# Bohannon Huston

April 30, 2012

Re: Cantata at the Trails, DRB 1002962 (C-09/D001B)

This letter is an addendum to the approved drainage report for Cantata at the Trails, dated 8/22/07. The purpose of this addendum is to remove Sump Inlet 8 (and corresponding storm drain), at the intersection of Streets #4 and #10, as shown on the attached drainage basin map. This inlet is being removed because Street 10 has capacity to carry the 14.92 cfs at Sump Inlet 8, plus the 4.51 cfs from Basin 3A1, to Sump Inlet 12 at the intersection of Streets #2 and #10. In addition, Inlet 12 has the capacity to pass 21.2 cfs (14.92 cfs from Inlet 8 and 6.3 cfs from Inlet 12).

No. Date Issue / Description  
 10/27/12 STORM DRAIN REVISION

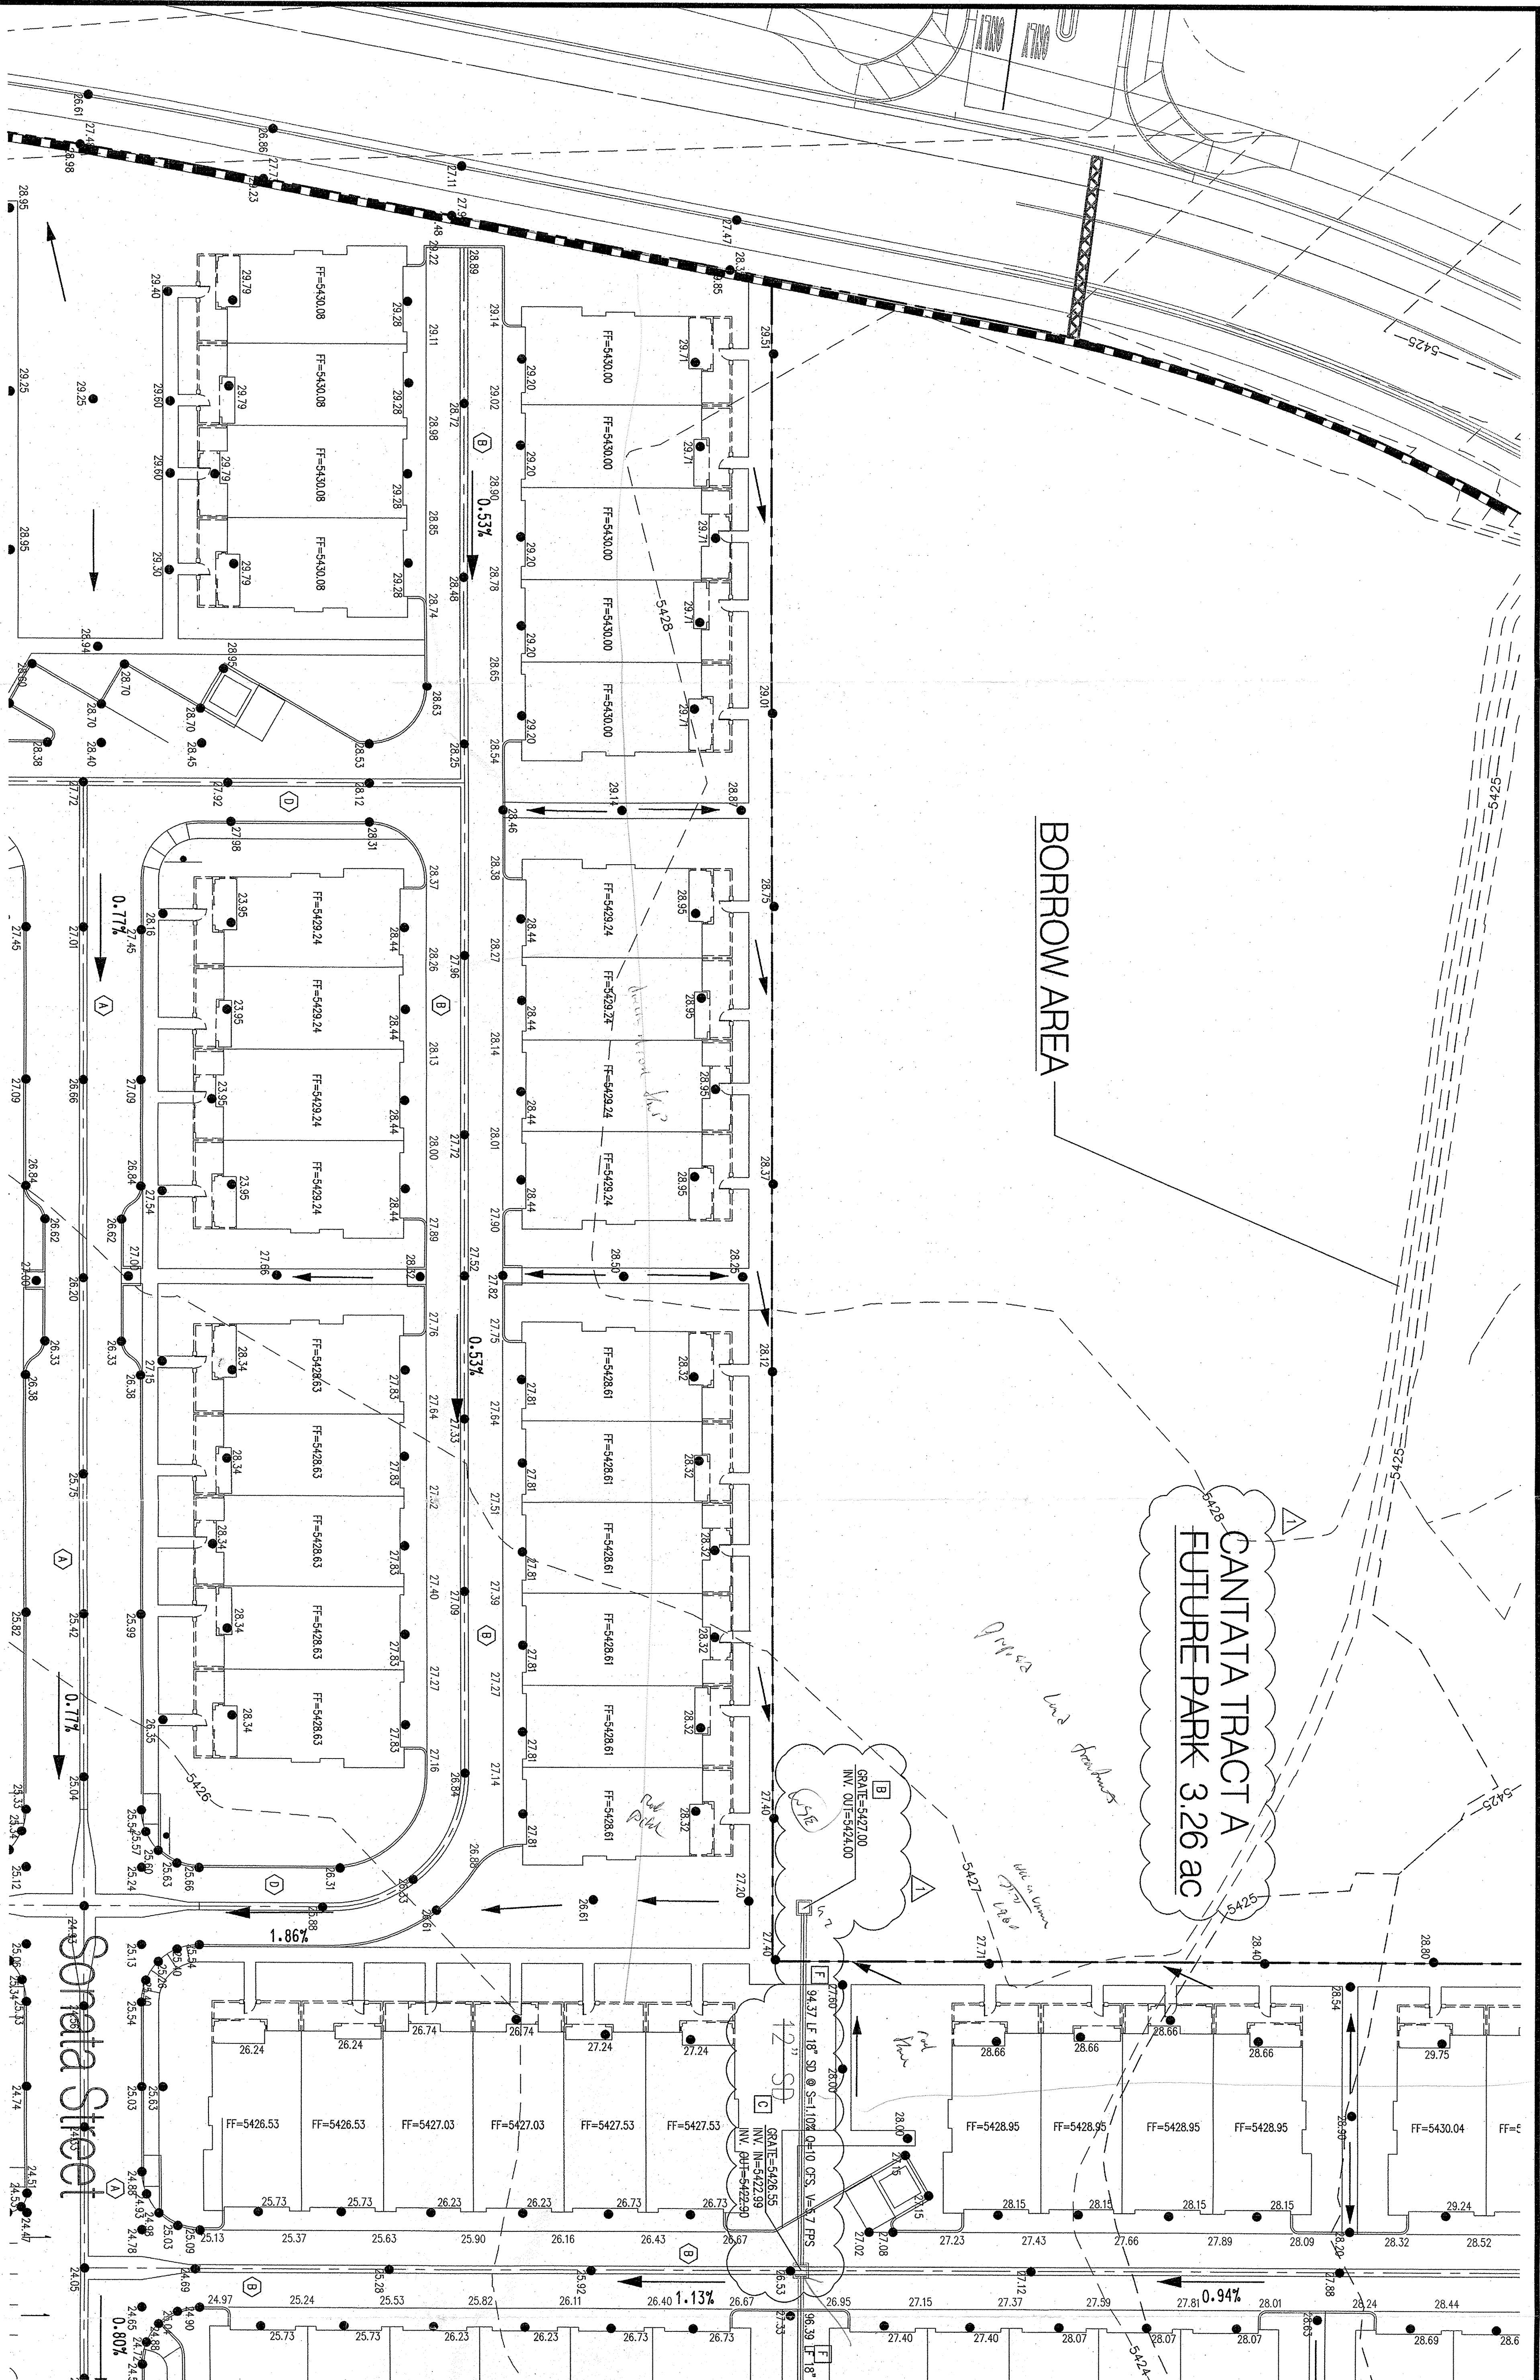
Enclosed for your review is the revised Cantata Tract B grading plan showing the revision to the storm drain serving Cantata Tract A. This revision is pursuant to Item #10 of the Memorandum of Agreement between the City, RCS and The Trails. The purpose of the storm drain revision is to accommodate an increase in developed flows from Tract A due to a zoning change from park to multi-family.

The attached storm drain hydraulic analysis is based on the hydraulic grade line (HGL) elevation in Universe Boulevard where the Cantata storm drain connects to the proposed storm drain in Universe. The HGL elevation was provided by Thompson Engineering Consultants (TEC) and is based on the 100-year, 6-hour analysis performed by TEC for the Universe storm drain. The allowable discharge from Tract A has increased from 1 cfs to 10 cfs based on the revised storm drain design. The 100-year, 6-hour runoff from Tract A is 12.7 cfs  $\frac{3.26}{3.26} \approx 3.9 \text{ cfs}$

The additional 2.7 cfs will need to be accommodated for in the design of Tract A. Depending on the proposed grading plan for Tract A, the flow may be directed to Oakridge Street or Cantata Tract B. The drainage report for Tract A will need to include an analysis of capacity in Oakridge Street (and downstream storm drain) and/or Cantata Tract B to show there is sufficient capacity to accept flow from Tract A. If there is insufficient capacity to accept the flows on-site detention ponding will be required on Tract A.

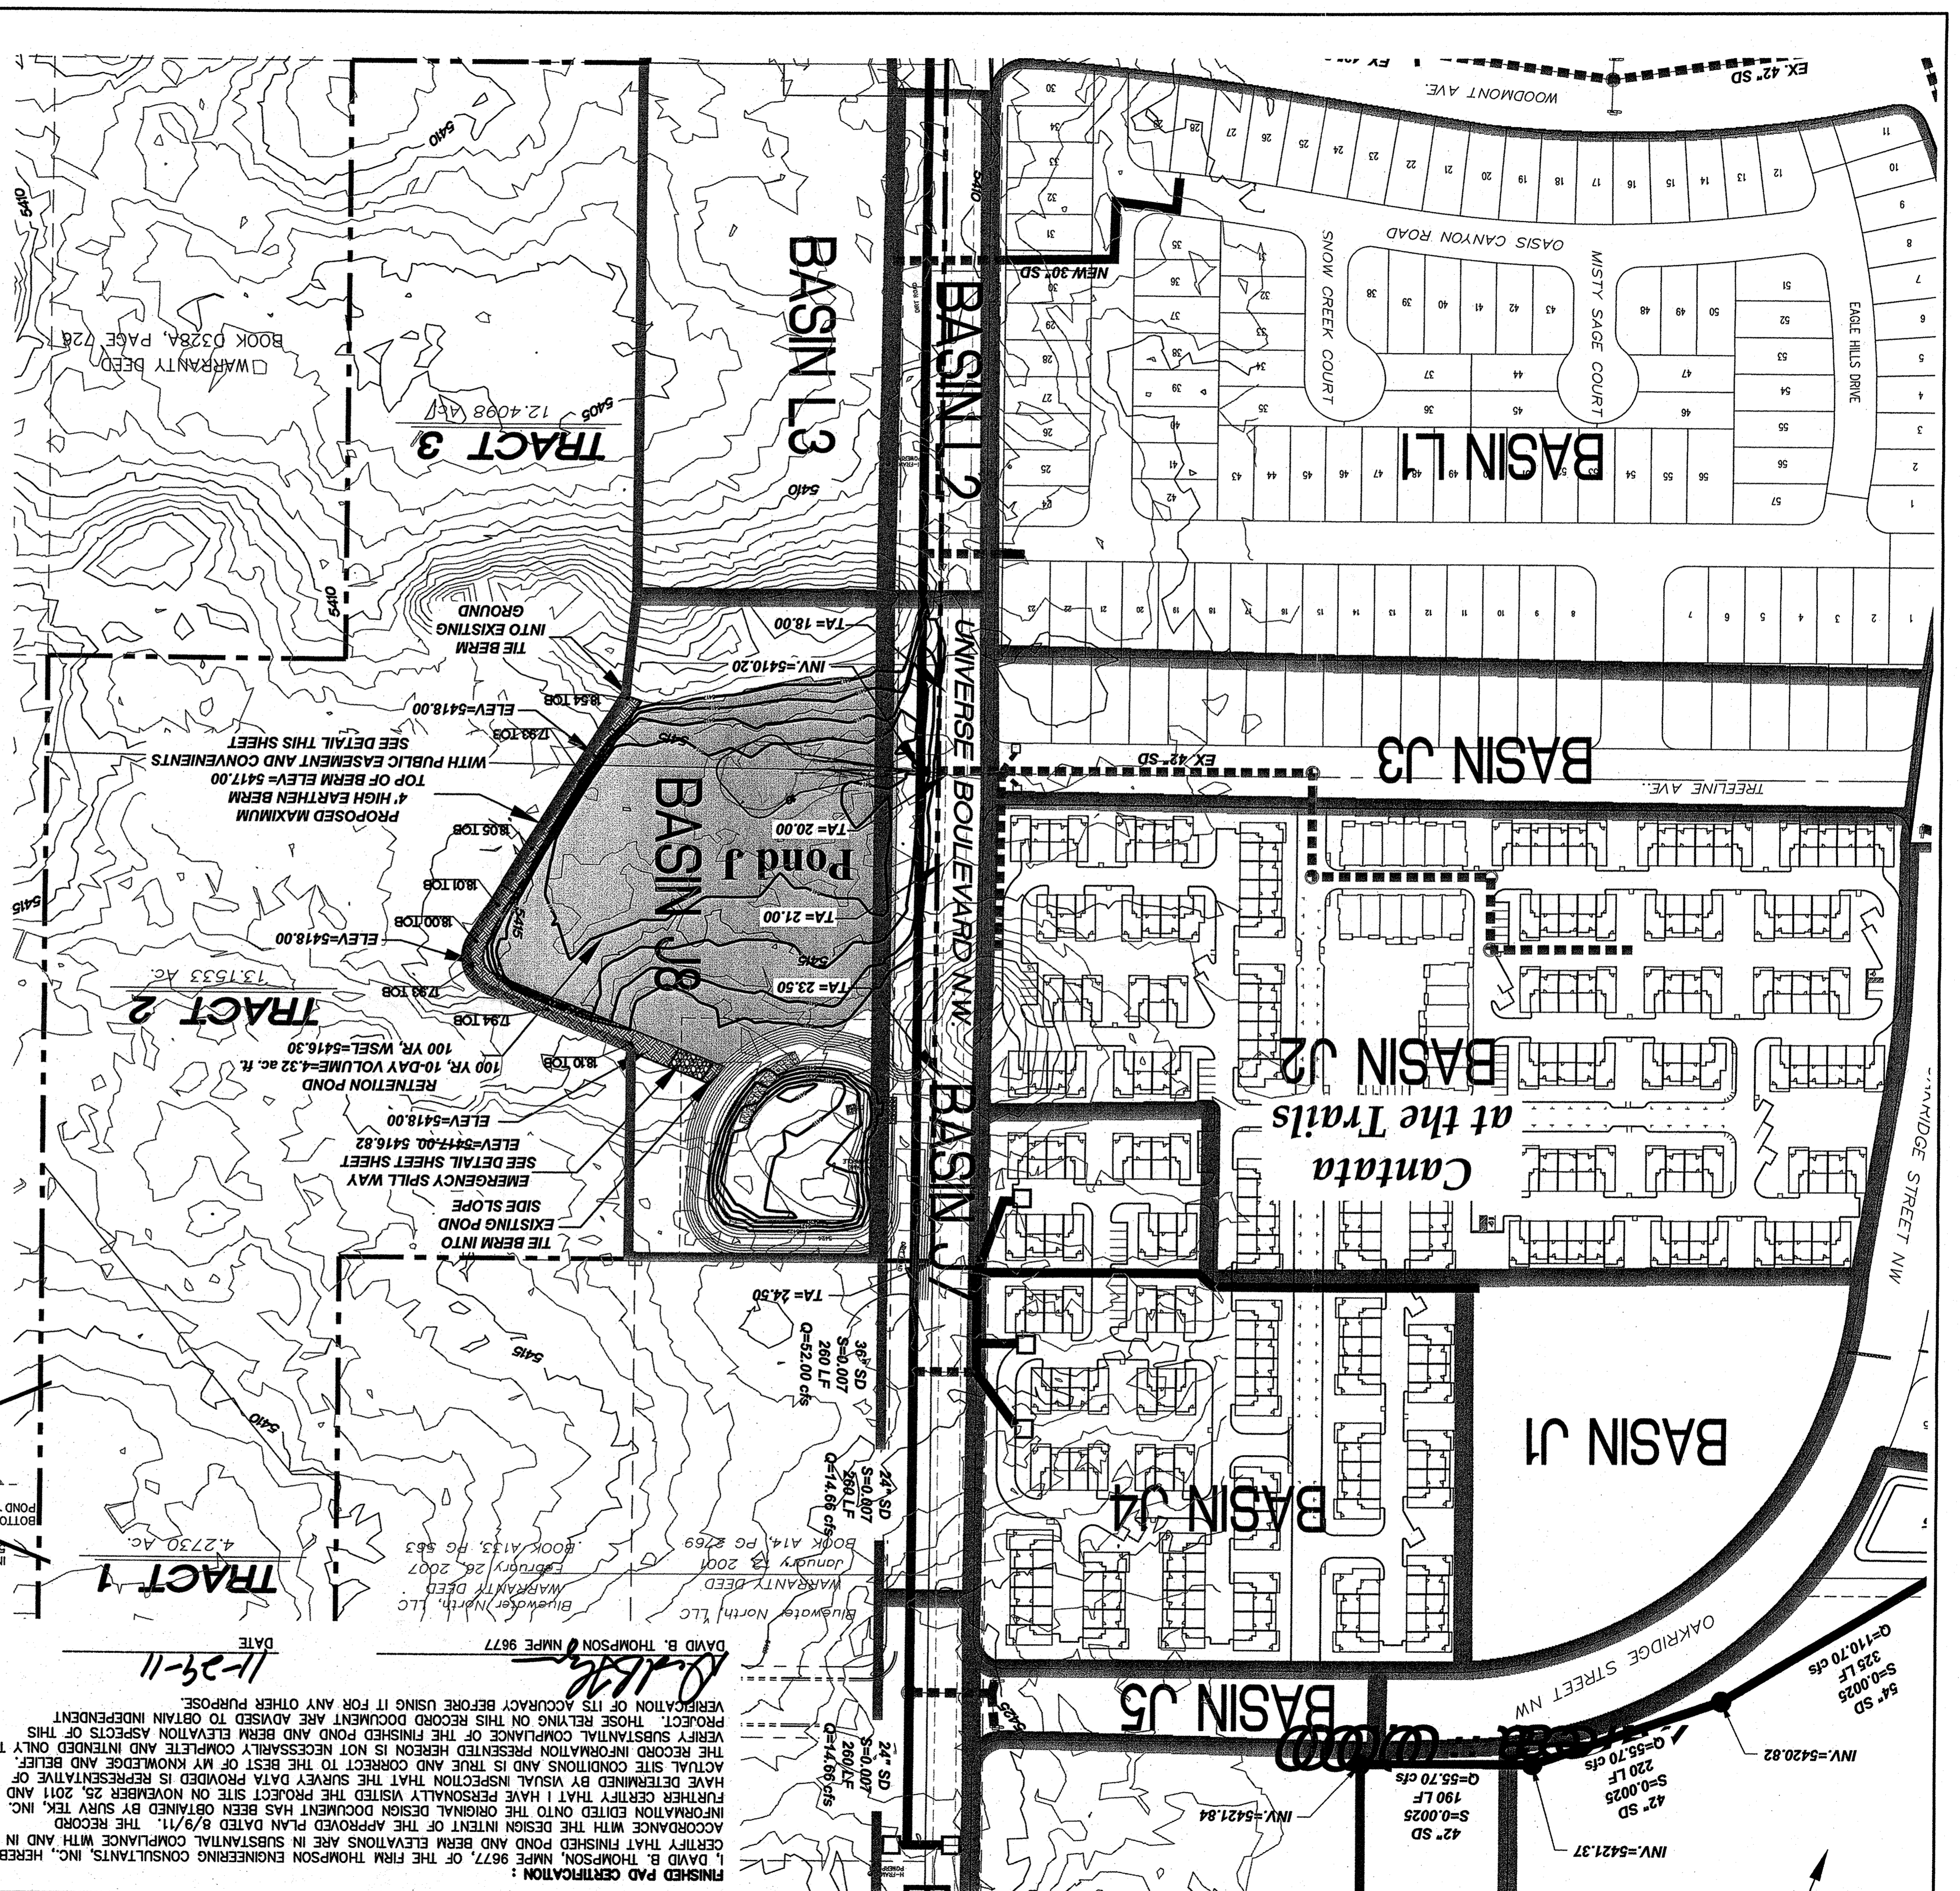
This addendum shows that Street 10 can safely convey flows to Sump Inlet 12 and that Sump Inlet 12 has the capacity to accept these additional flows. Therefore, Sump Inlet 8 and the 24-inch storm drain between inlets 12 and 8 are not required for the site to drain.
